Comments by F.J.R.Brown IP No. 20044329  
For submission by Deadline 3  
of the EN010117 Rampion Wind Farm Examination

This is a response to the Applicant's Deadline 2 Document 8.53 Category 8 Applicant's Response to Non-Prescribed Consultees' Written Representations- Appendix C

## **Comments on some of the Photo Montages and figures in Chapter 15**

Figure 15.50e
 Viewpoint 27: Hollingbury Golf Course/Hill Fort

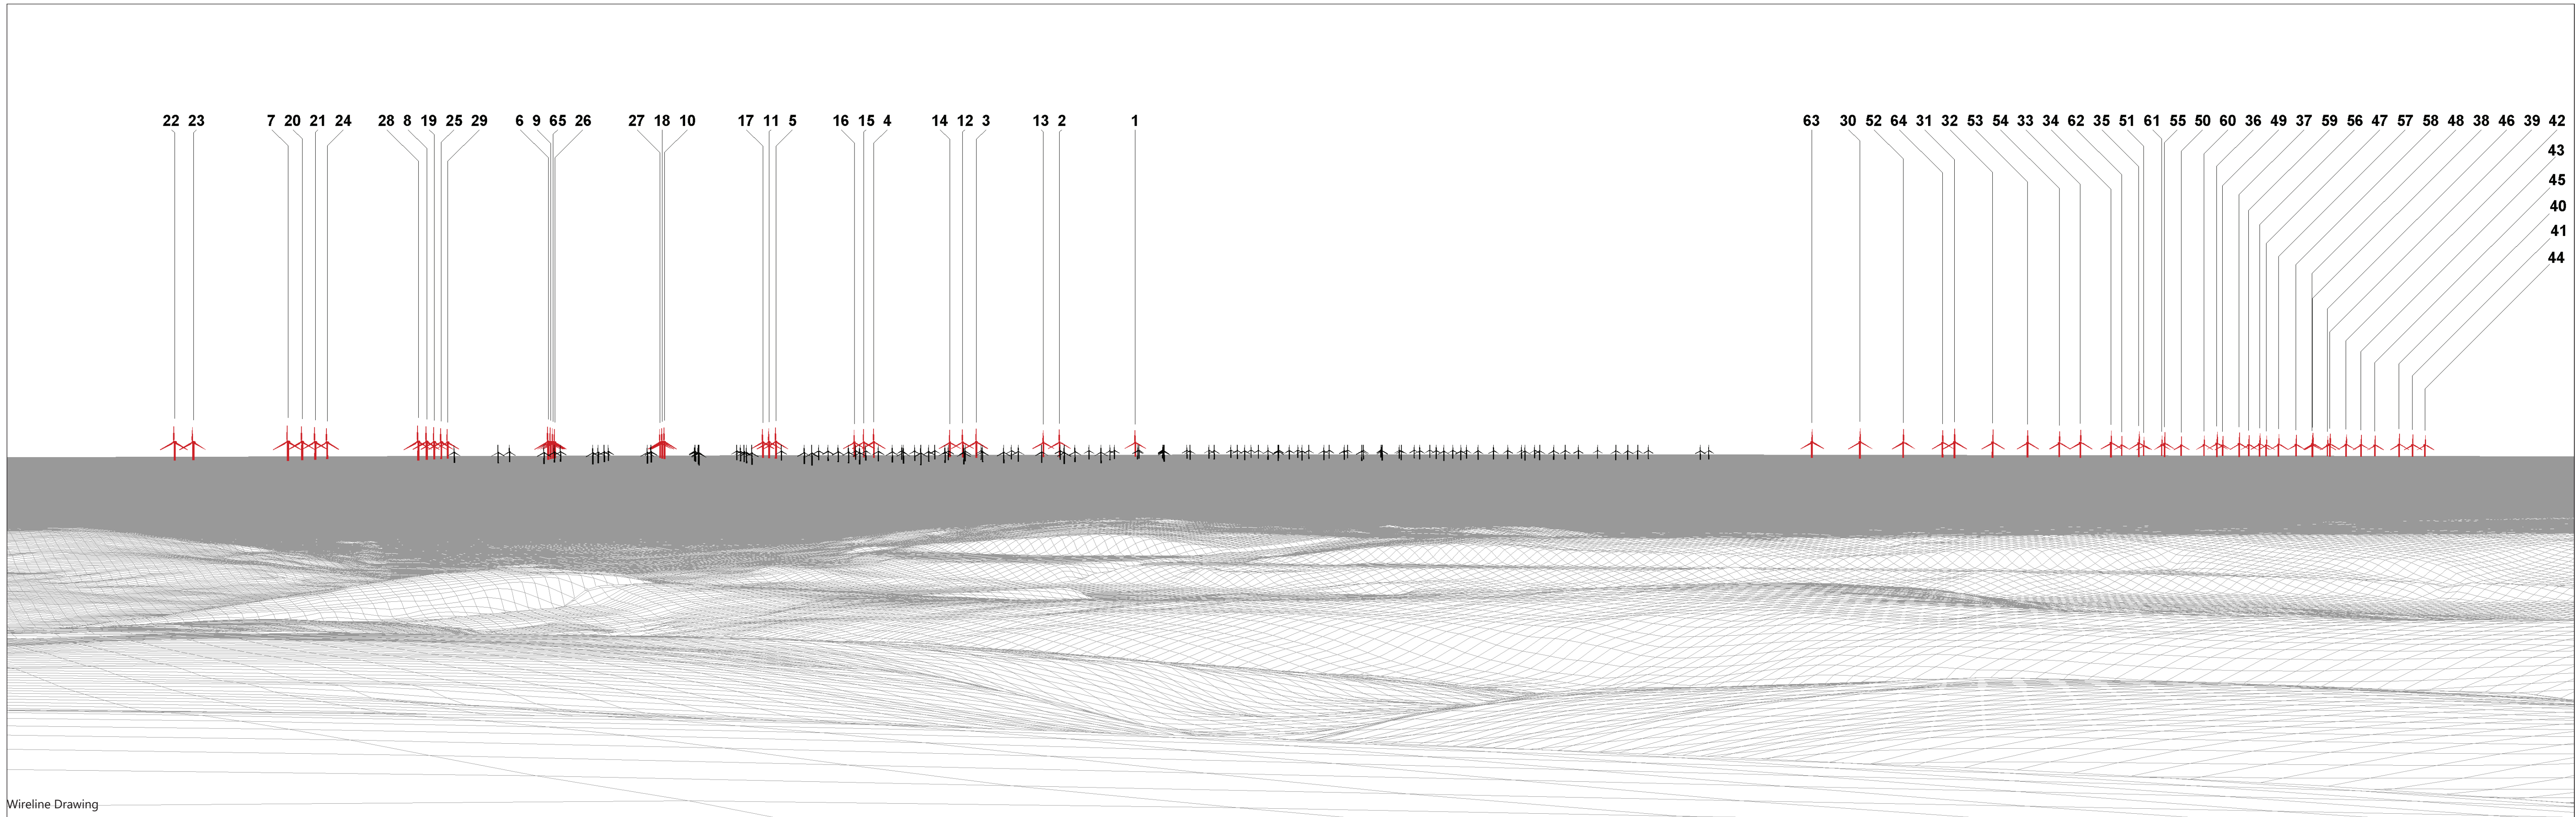
**Figure 15.50a-h Viewpoint 27 Hollingbury Golf Course/Hill Fort**

The night views show the extent (but not the depth) of the aerial navigation lights.

Given the amount of street lighting, floodlighting, and other kinds of lighting along the coast from east Brighton through to Southwick and Shoreham, this may appear to be an insignificant change, but remember these lights would be equally visible from parts of the Downs where there is little or no urban development.

(The Rampion 1 lights when pulsing are visible from many miles away from sea level, not just from the Downs)

Figure 15.63e  
Viewpoint 50: The Trundle

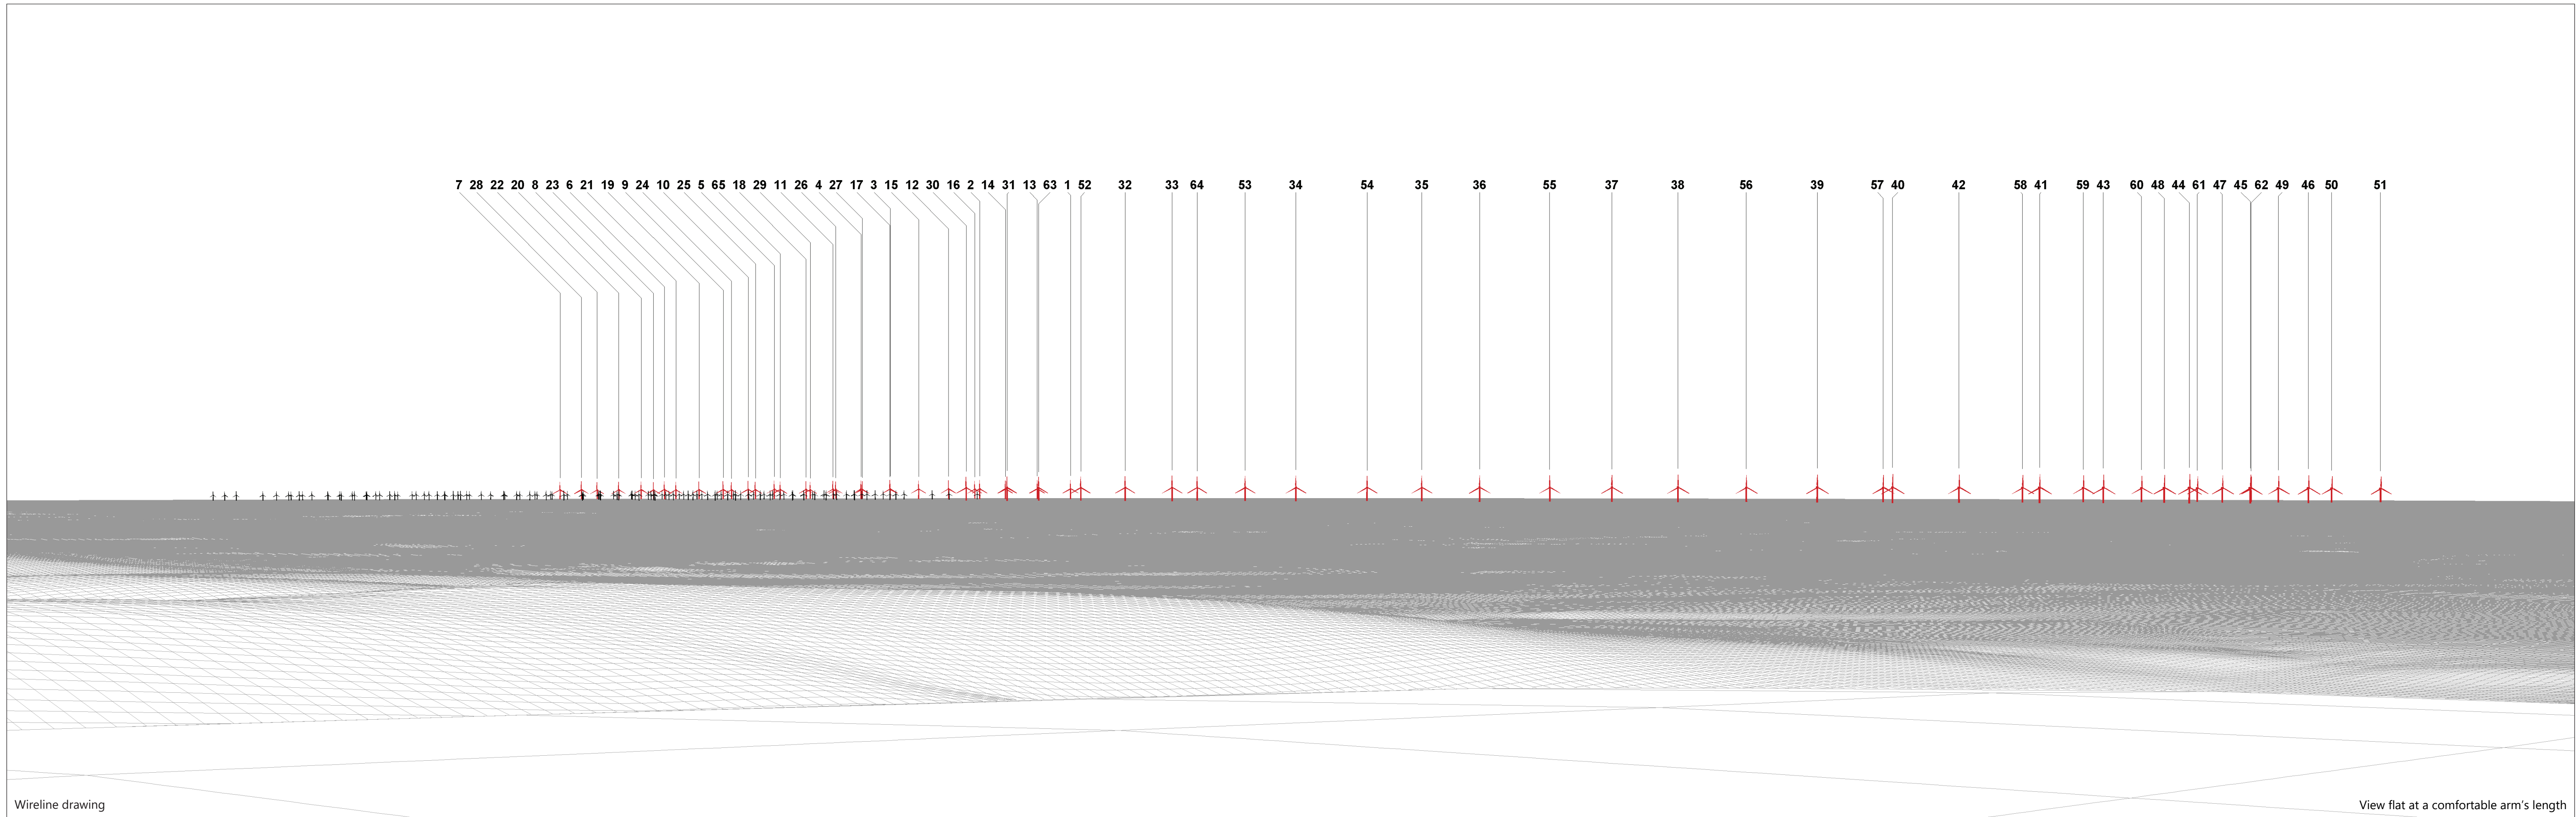
### **Figure 15.63a-f Viewpoint 50 The Trundle**

Figure 15.65f  
 Viewpoint 52: Chanctonbury Ring

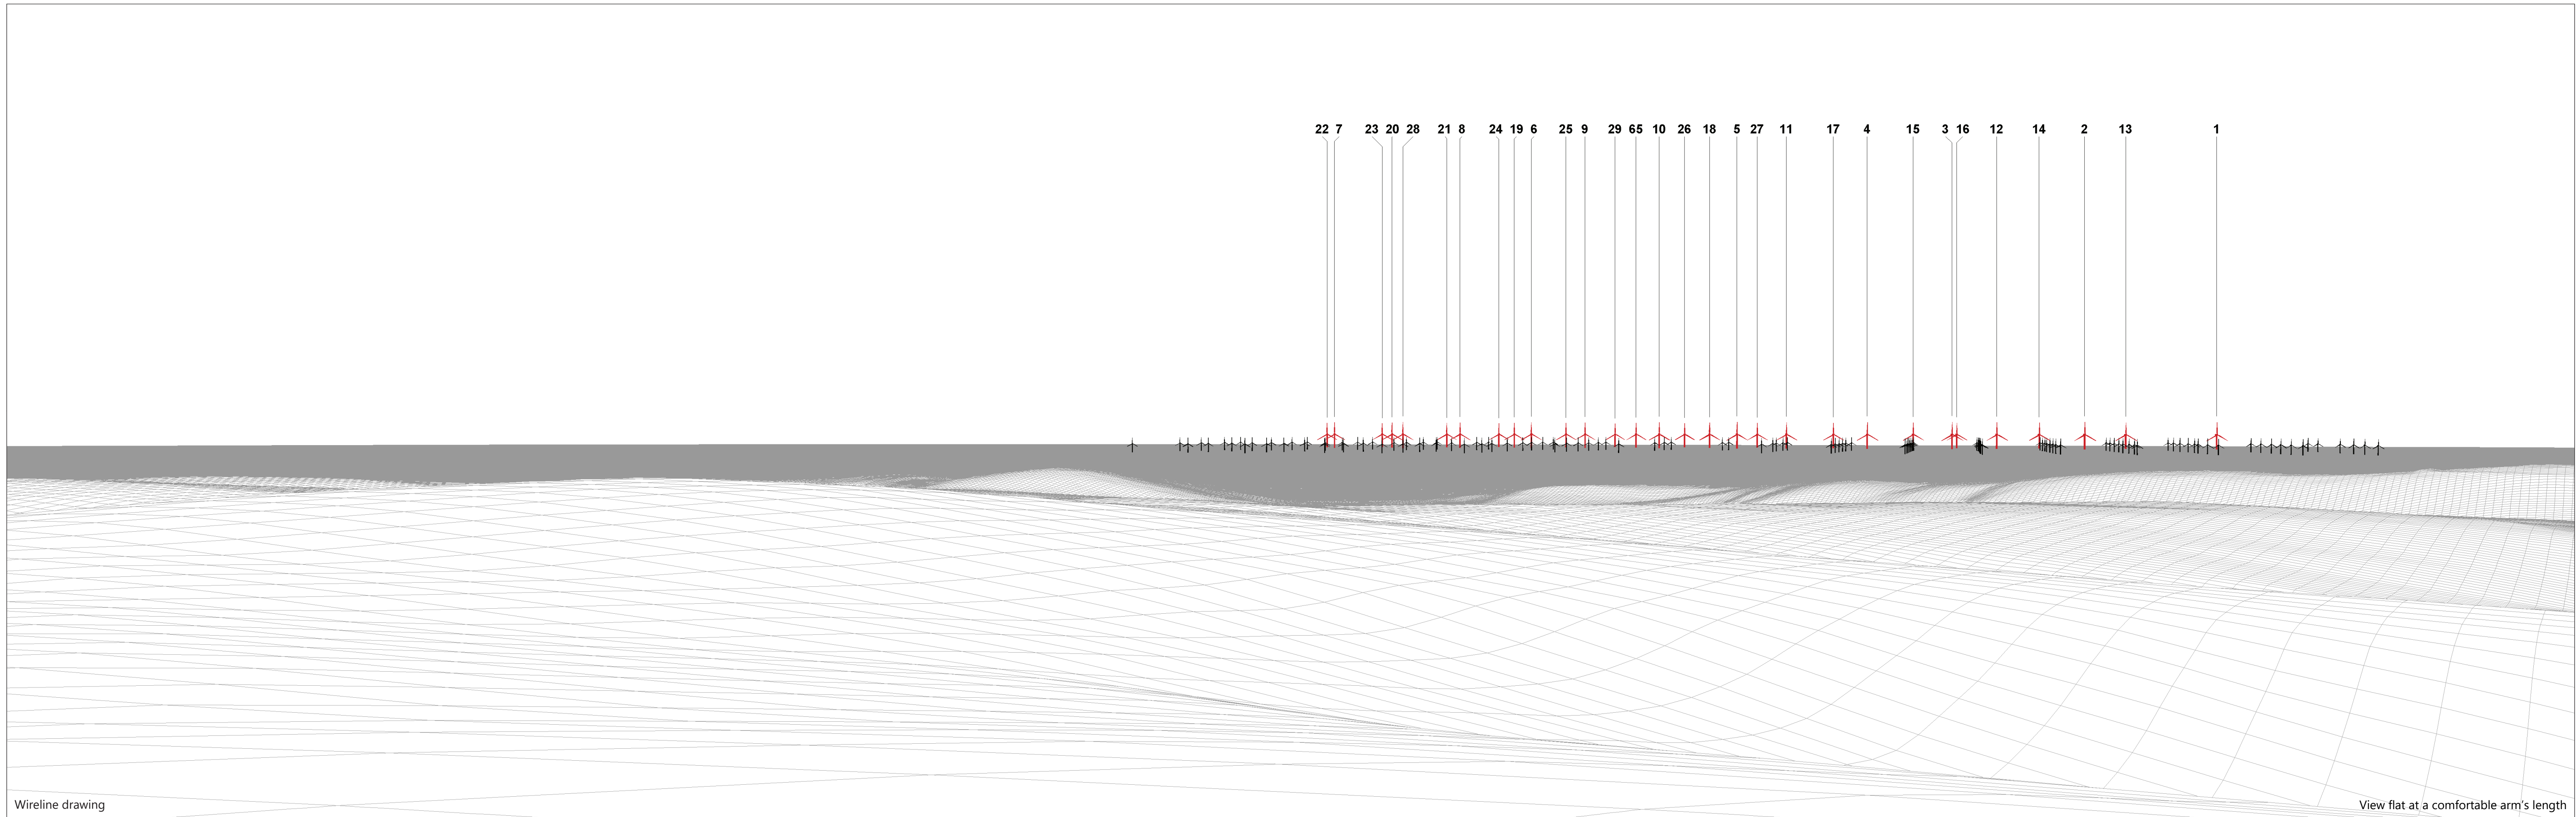
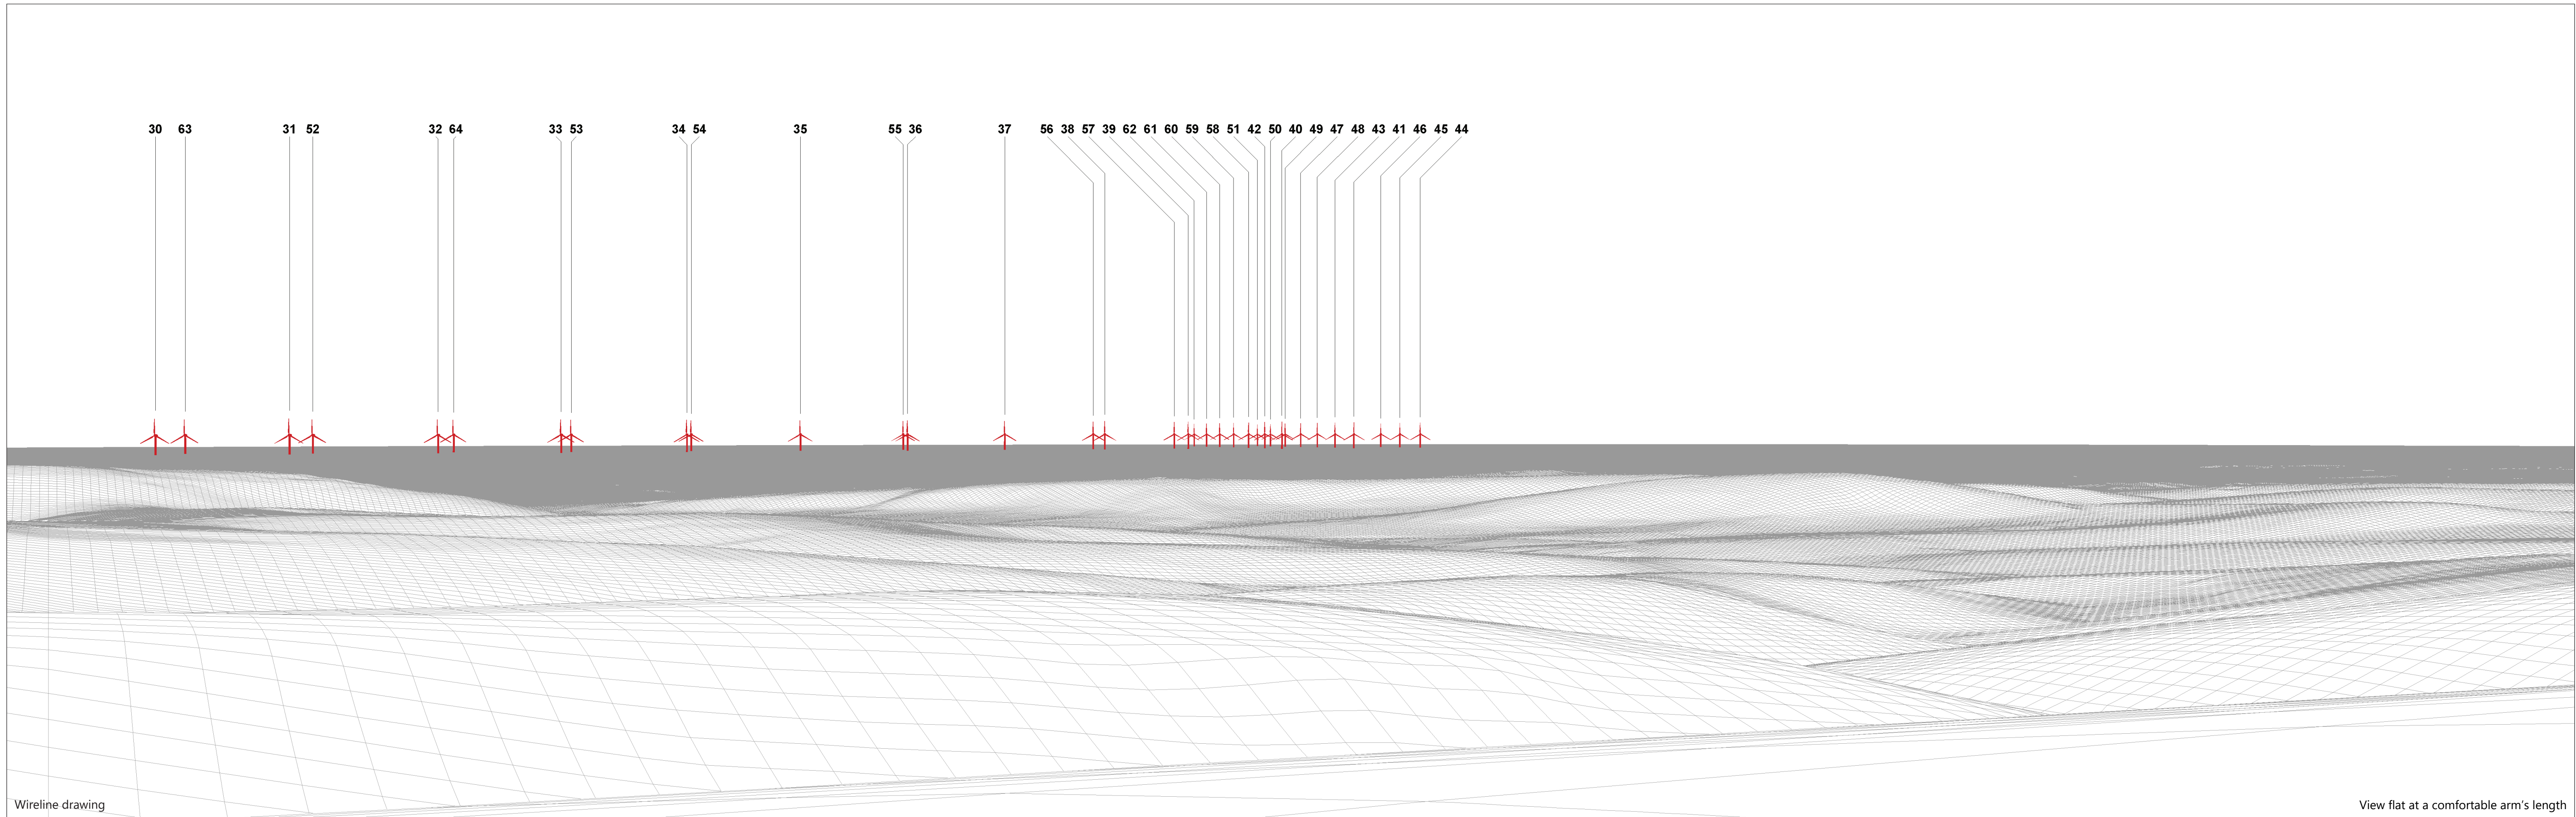
### **Figure 15.65a-h Viewpoint 52 Chanctonbury Ring**

Where the gradient of the dip slope conceals the majority of the urban development down the Findon Valley into Worthing, while the greater elevation raises the horizon and exposes a much larger expanse of the seascape – which is then abruptly fenced

by turbines, which also appear closer because their bases are more visible, and the footprint of the field more obvious.

Chanctonbury Ring has long been practically the most iconic feature of the Downs, being visible from much of mid- and west Sussex, since it was planted with trees in the 1700s.
